RE: Circle K – 9620 Eagle Ranch Rd. NW
Conceptual Grading & Drainage Plans
Engineer's Stamp Date: 03/08/23
Hydrology File: C13D028

RE: Circle K – 9620 Eagle Ranch Rd. NW
Conceptual Grading & Drainage Plans
Engineer's Stamp Date: No Date
Hydrology File: C13D028

Based upon the information provided in your submittal received 12/21/2022, the Conceptual Drainage Management Plan **is not** approved for action by the Development Facilitation Team (DFT) for Site Plan for Building Permit. The following comments need to be addressed for approval of the above referenced project:

FILE LOCATION: S:\CIRCLE K\IRVING & EAGLE RANCH\500 CADD\504 PLANS\CONSTRUCTION PLANS\GR03.DWG

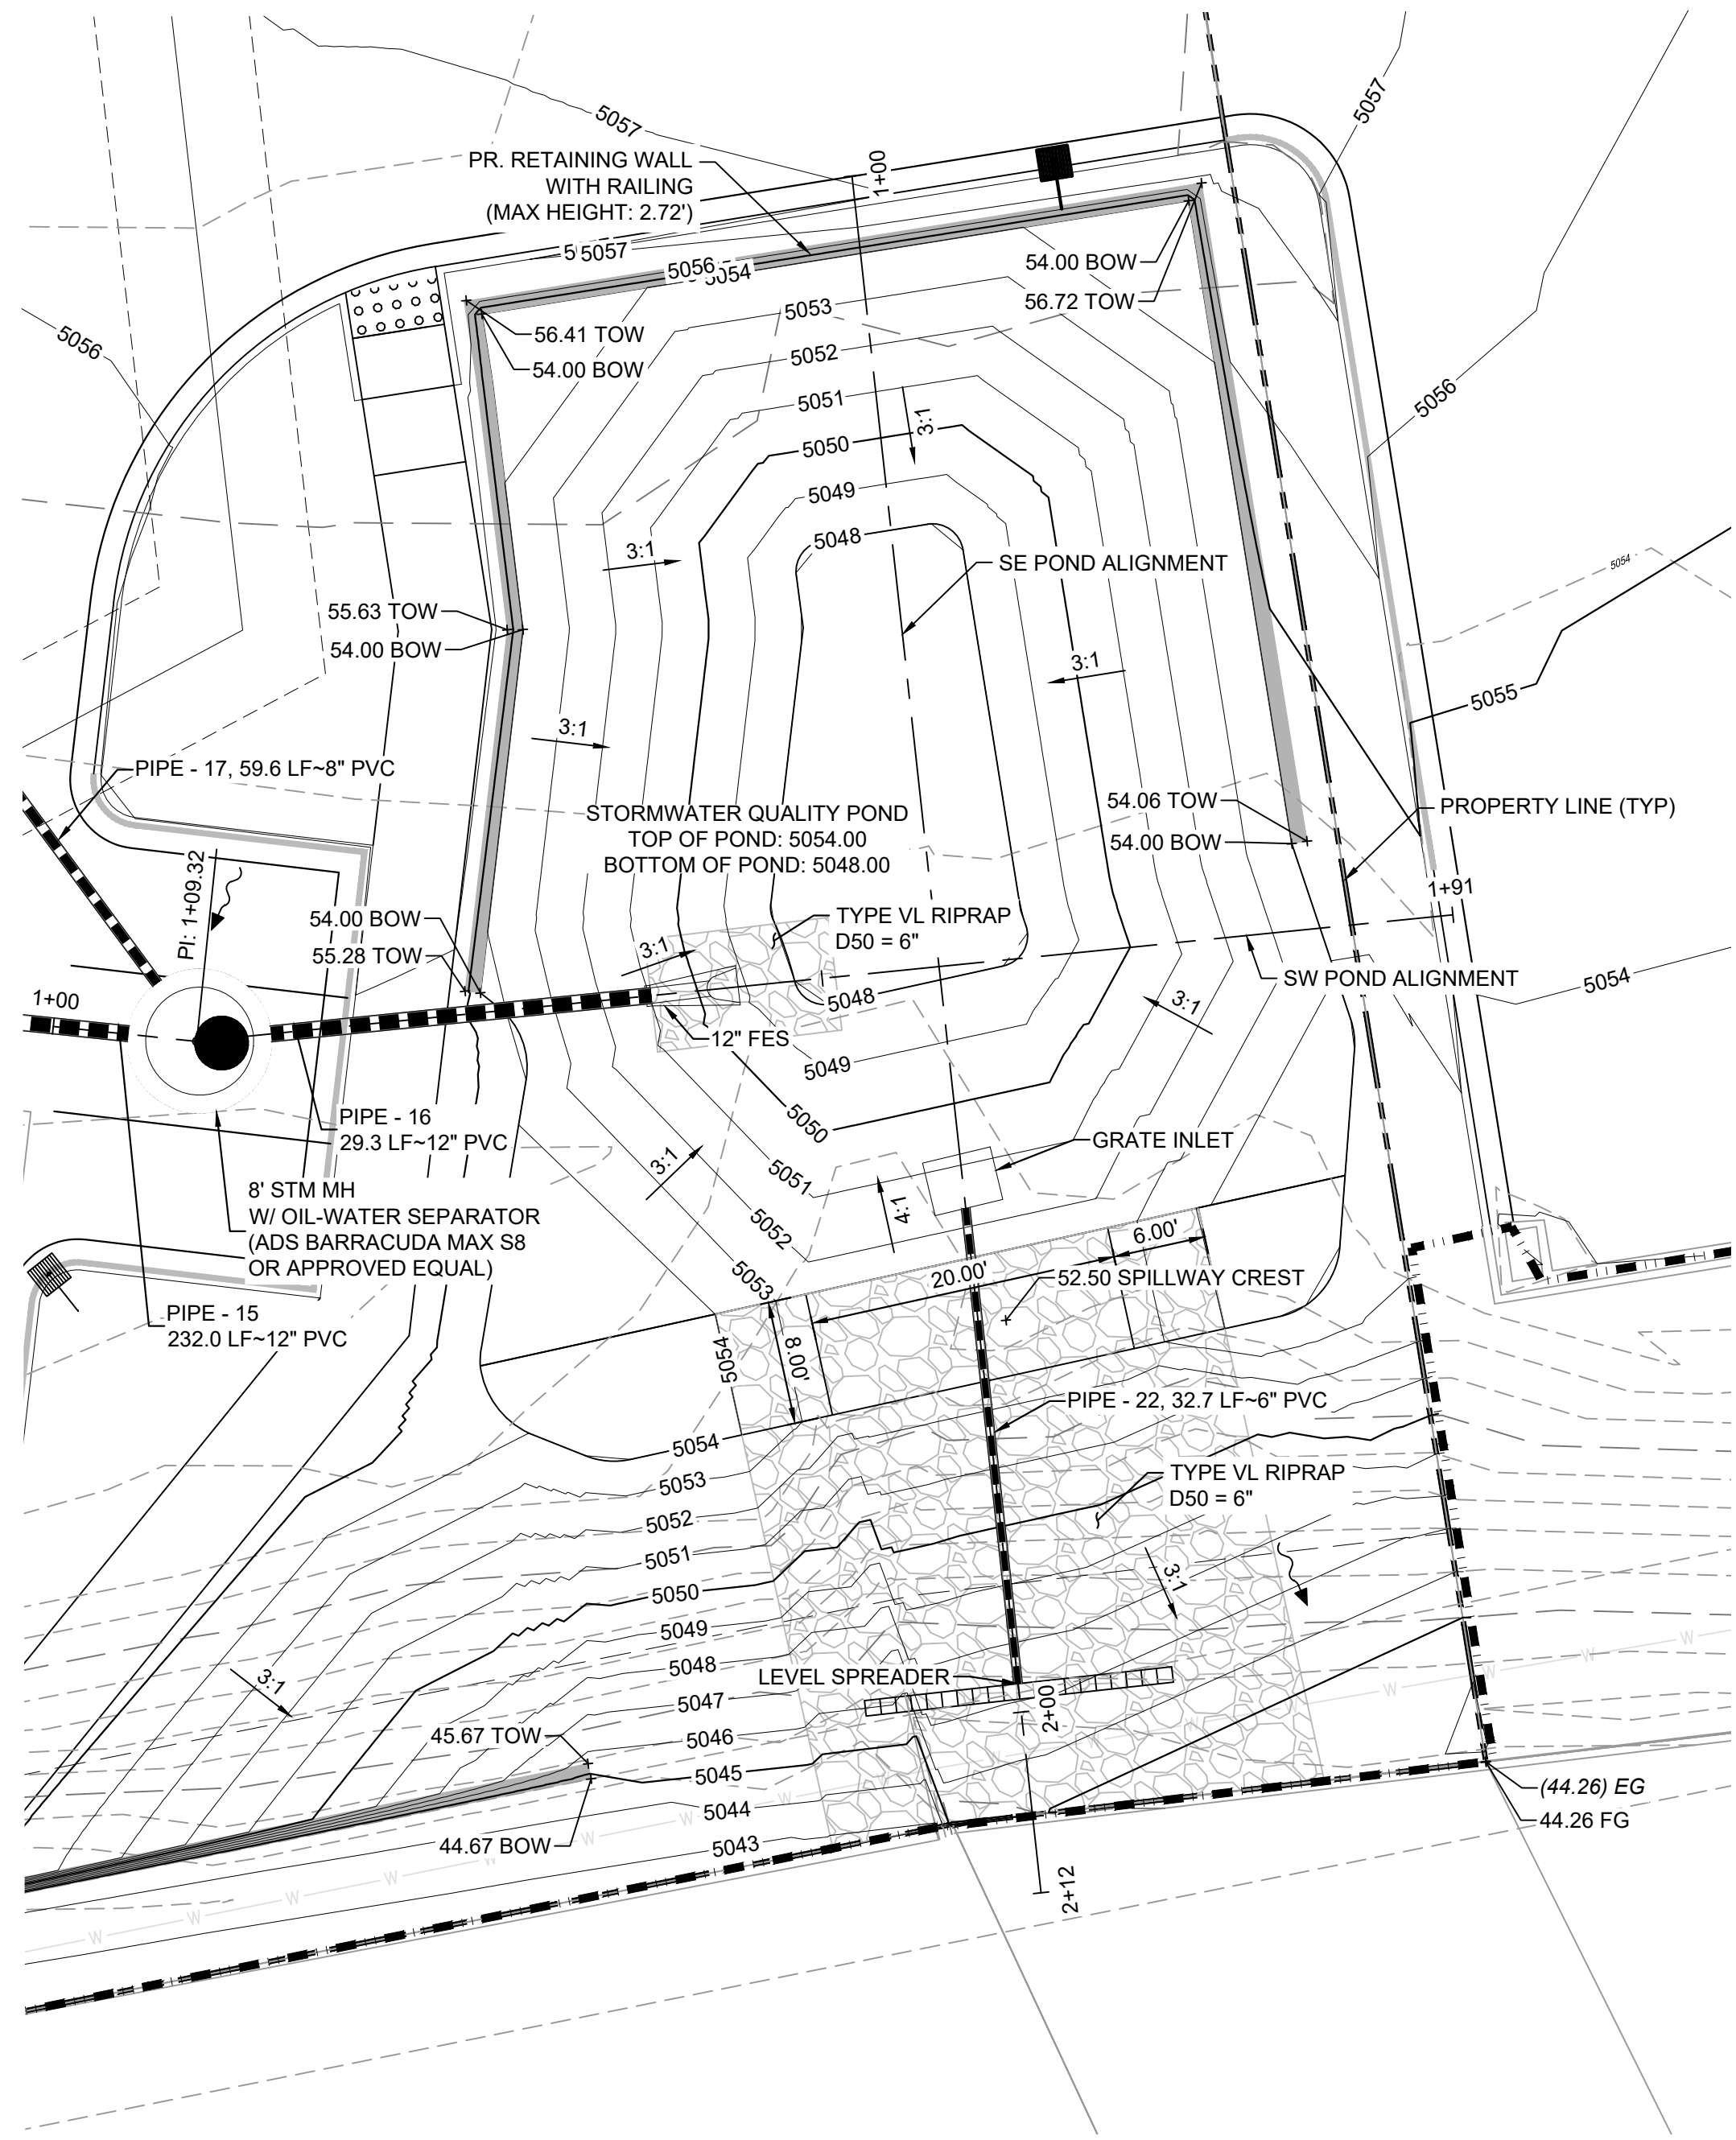
3. Please follow the DPM Article 6-12 Stormwater Quality and Low-Impact Development for the sizing calculations. To calculate the required SWQV, multiply the impervious area draining to the BMP by 0.42 inches for new development sites. For this site, the impervious area is 1.24 AC or **54,014.4 SF**. Times the SF by 0.42 then divide by 12. This gets a required SWQ volume of **1,890.50 CF**.

3. The SWQV has been updated per the calculation provided in DPM Article 6-12.
4. Pond sections are now included.
5. An oil/water separator is now proposed. An ADS Barracuda Max, model S6 is proposed in a 6-foot diameter manhole.

SE POND PROFILE  
SCALE: (H) 1" = 10' (V) 1" = 5'  
START STA: 1+00.00, END STA: 2+11.76

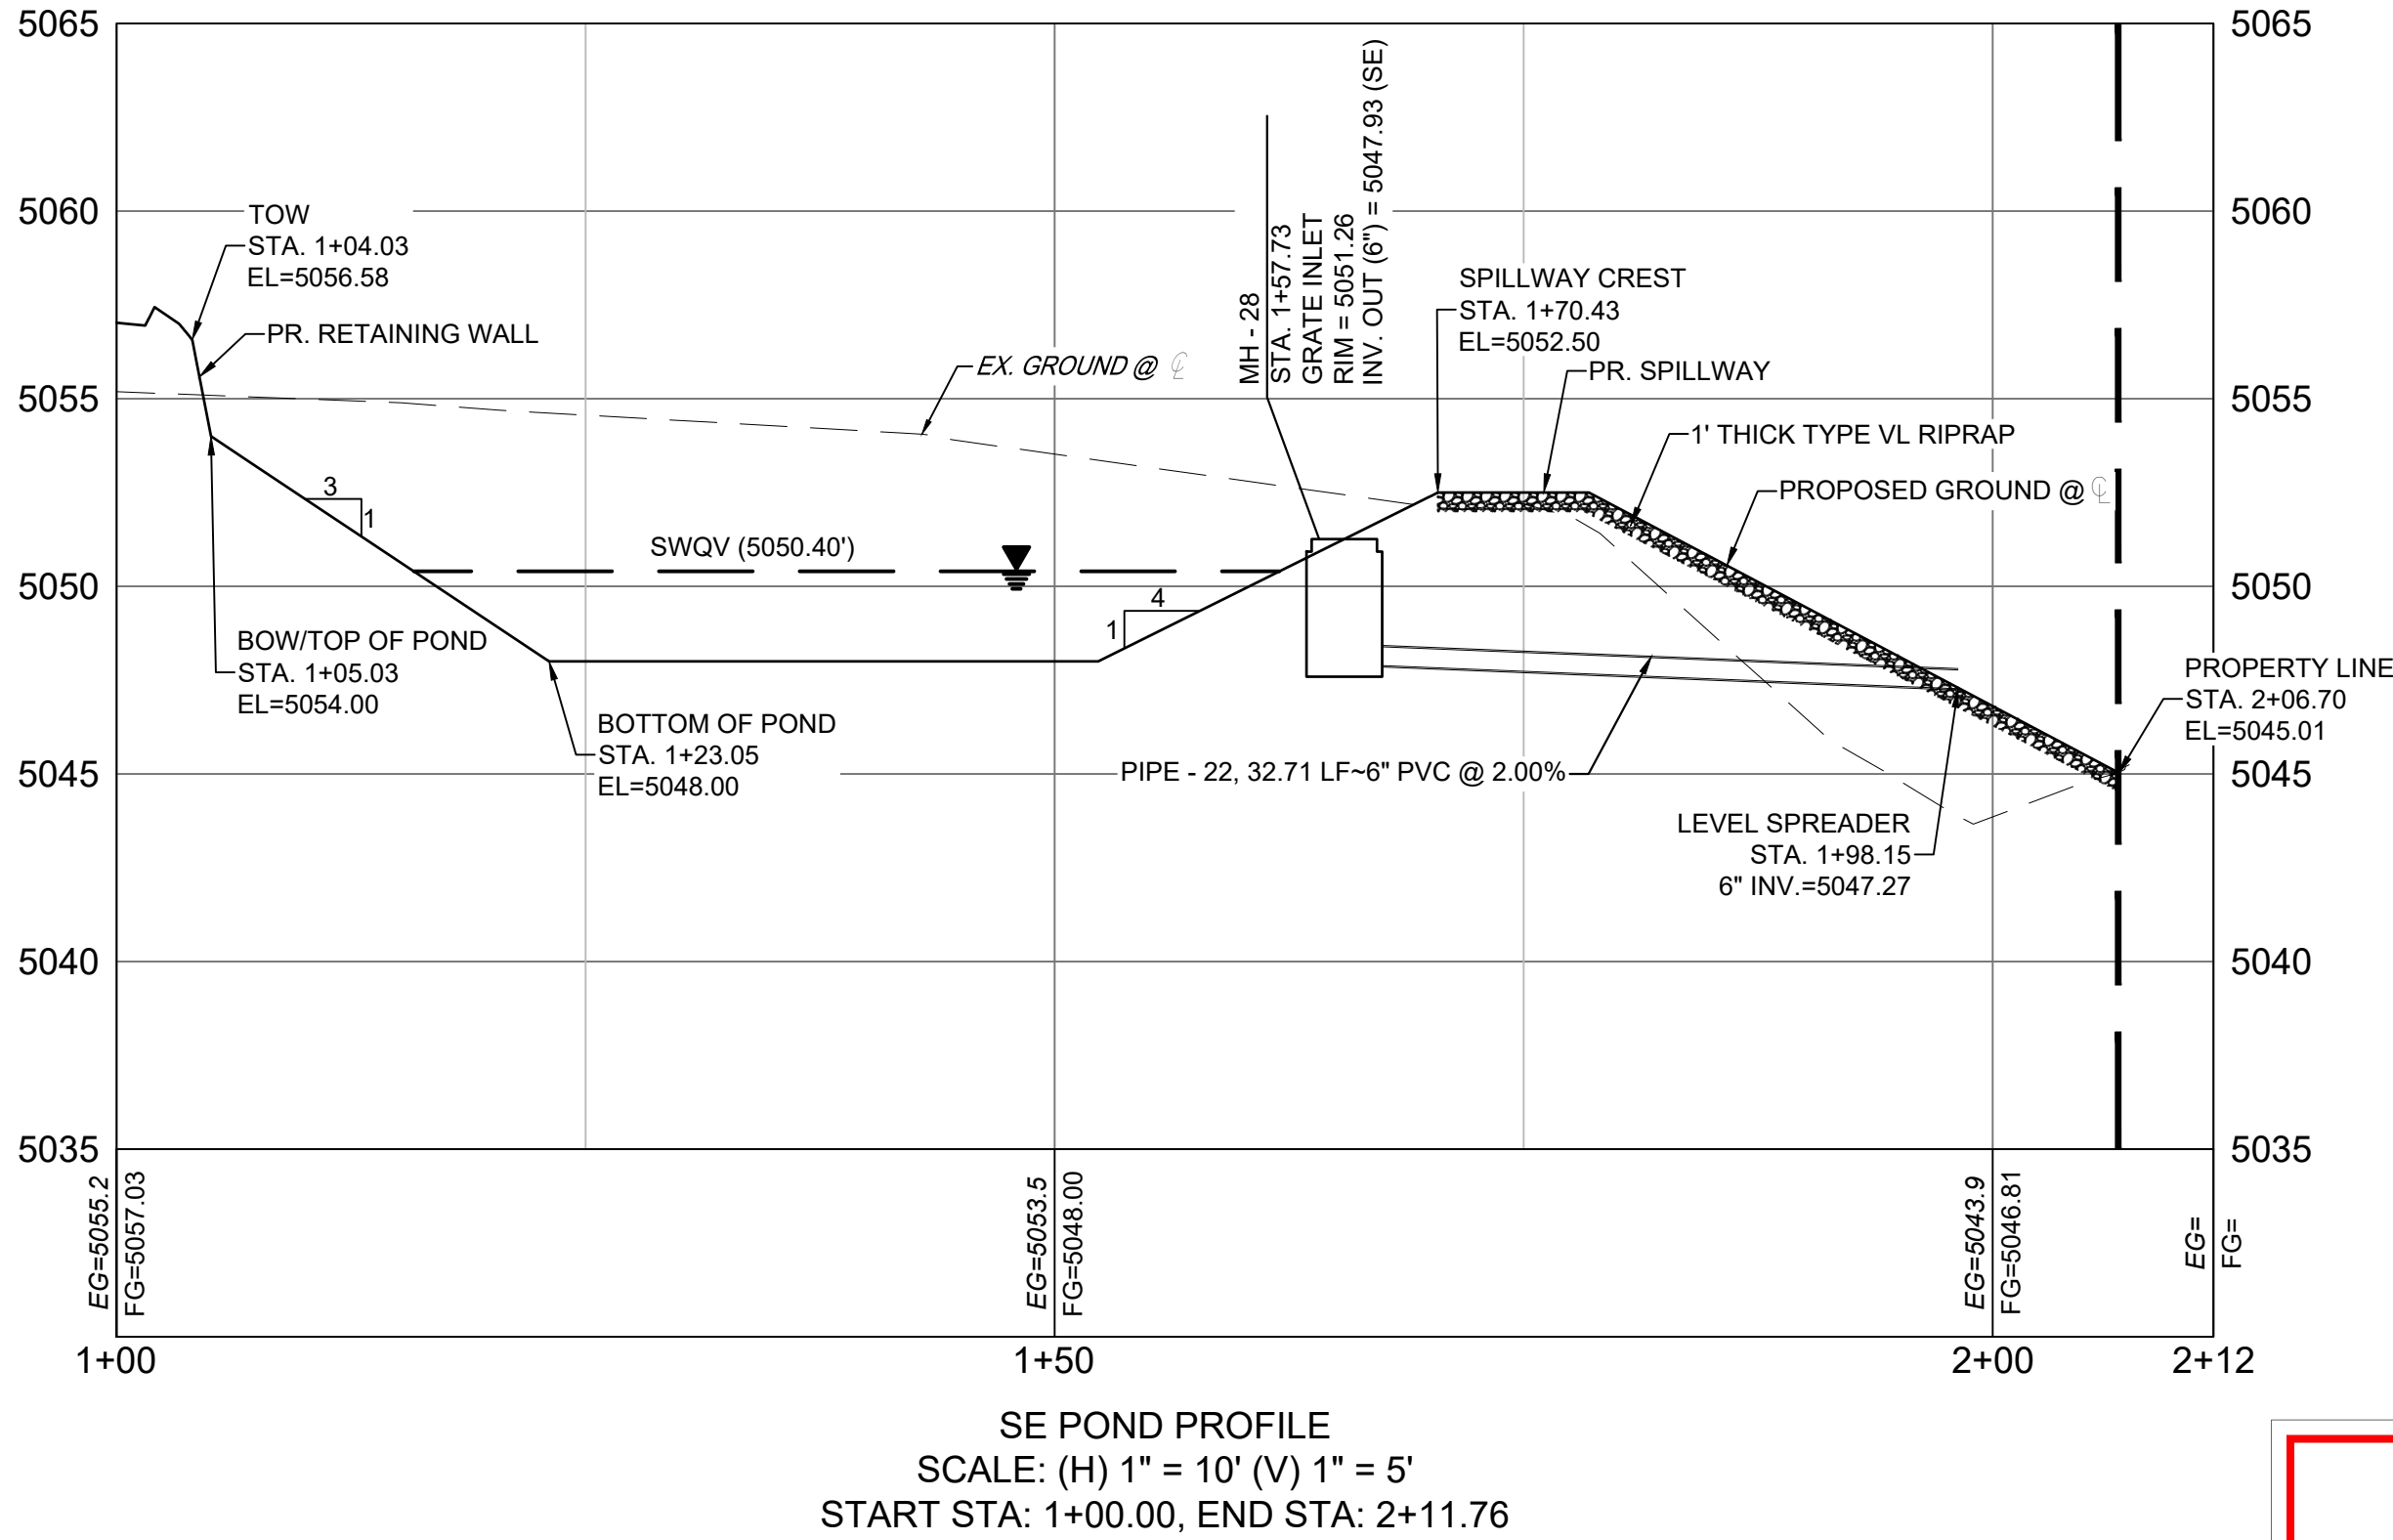
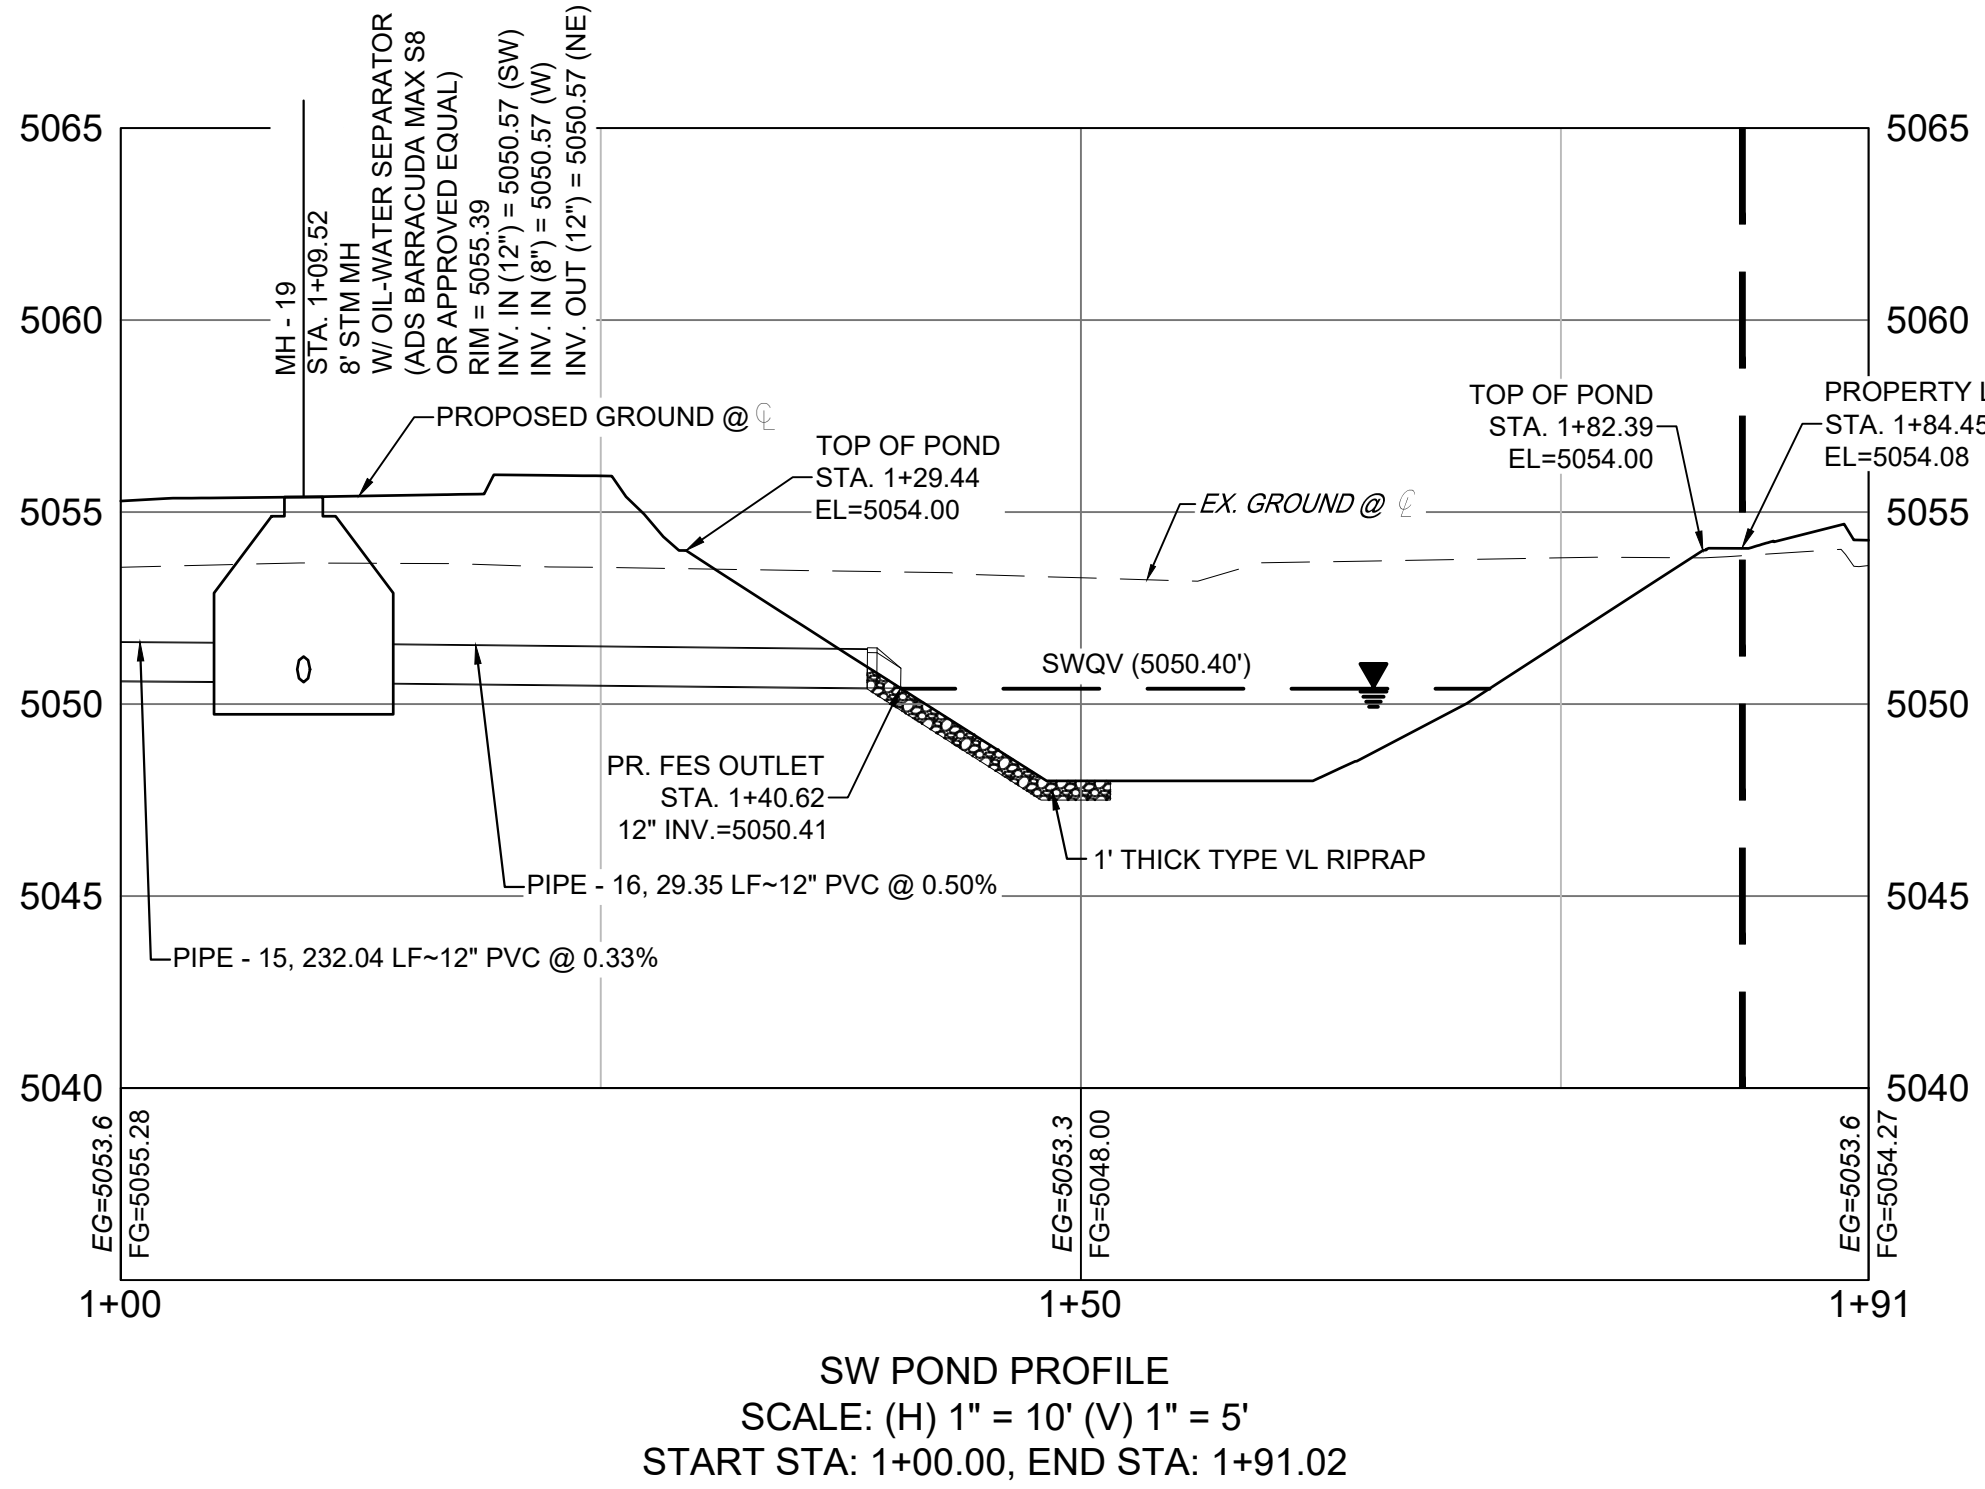
4. Please provide sections of the Stormwater Quality Pond. This should include the top of pond elevation, bottom of pond elevation, side slopes, Stormwater Quality water surface elevation (the required volume). Also include items such as retaining walls, pipes with inverts coming into the pond, and the outfall structure or emergency spillway.
